ENG-SF21021-R3-FDR.pdf Markup Summary

**CALCULATED WQCV RESULTS**

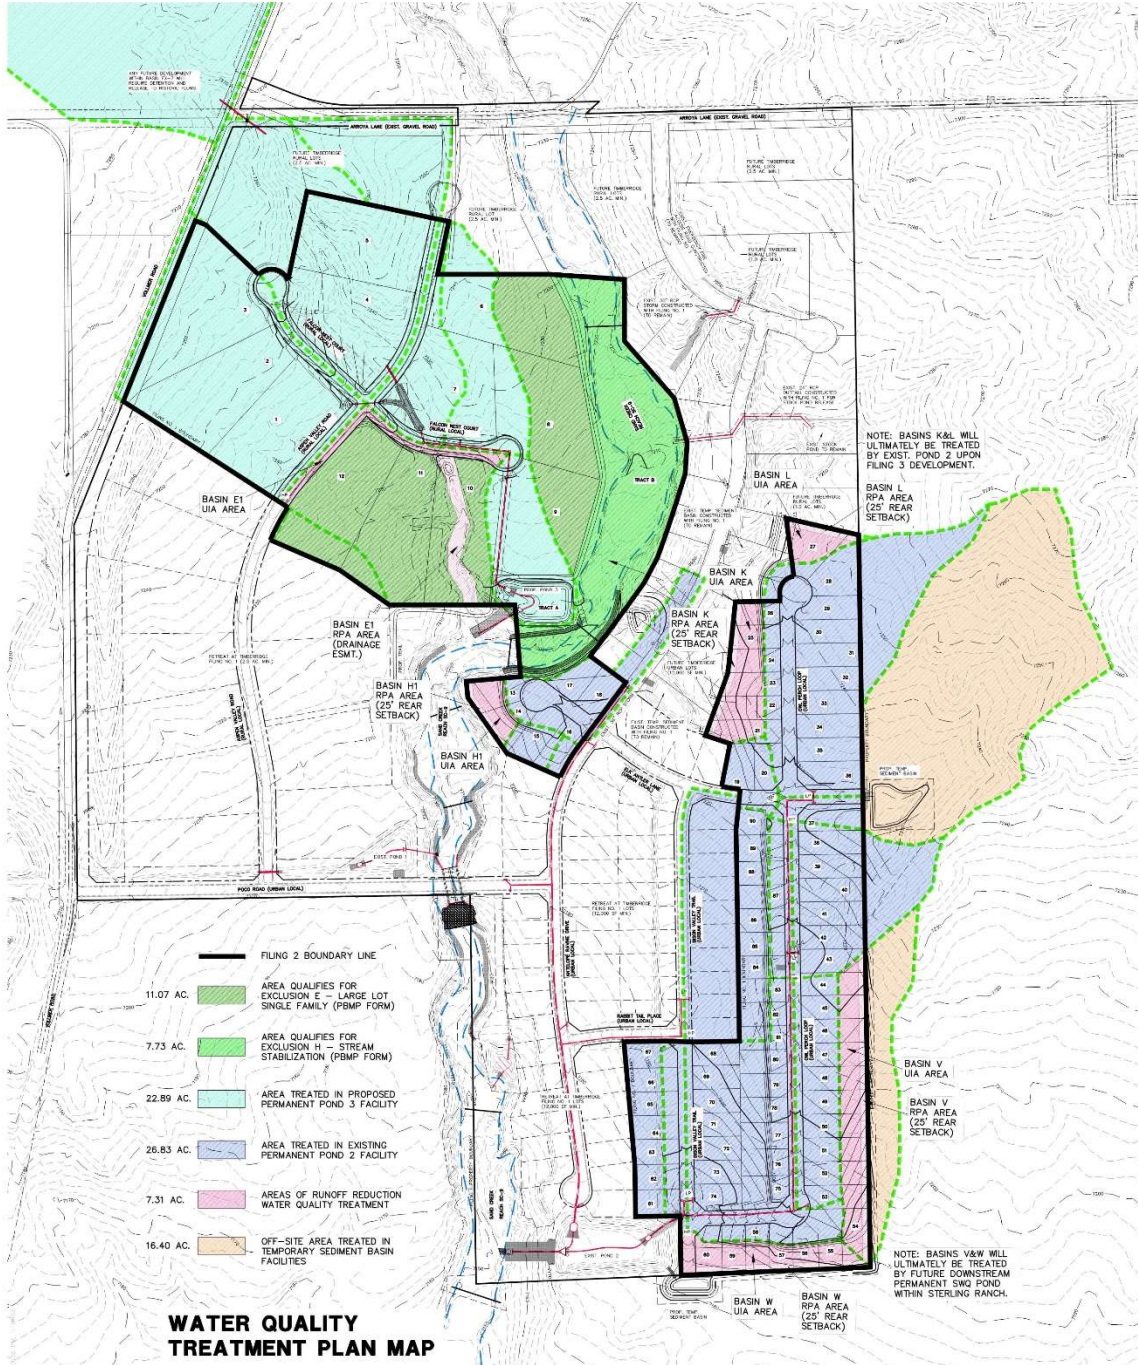
add a columns for basins W and V

to reduce the no build easement areas on private property, only 60% of the WQCV needs to be treated to meet runoff reduction standards.

As long as the area ID is by basin, all calculations can be shown on 1 sheet, with a separate column for each basin
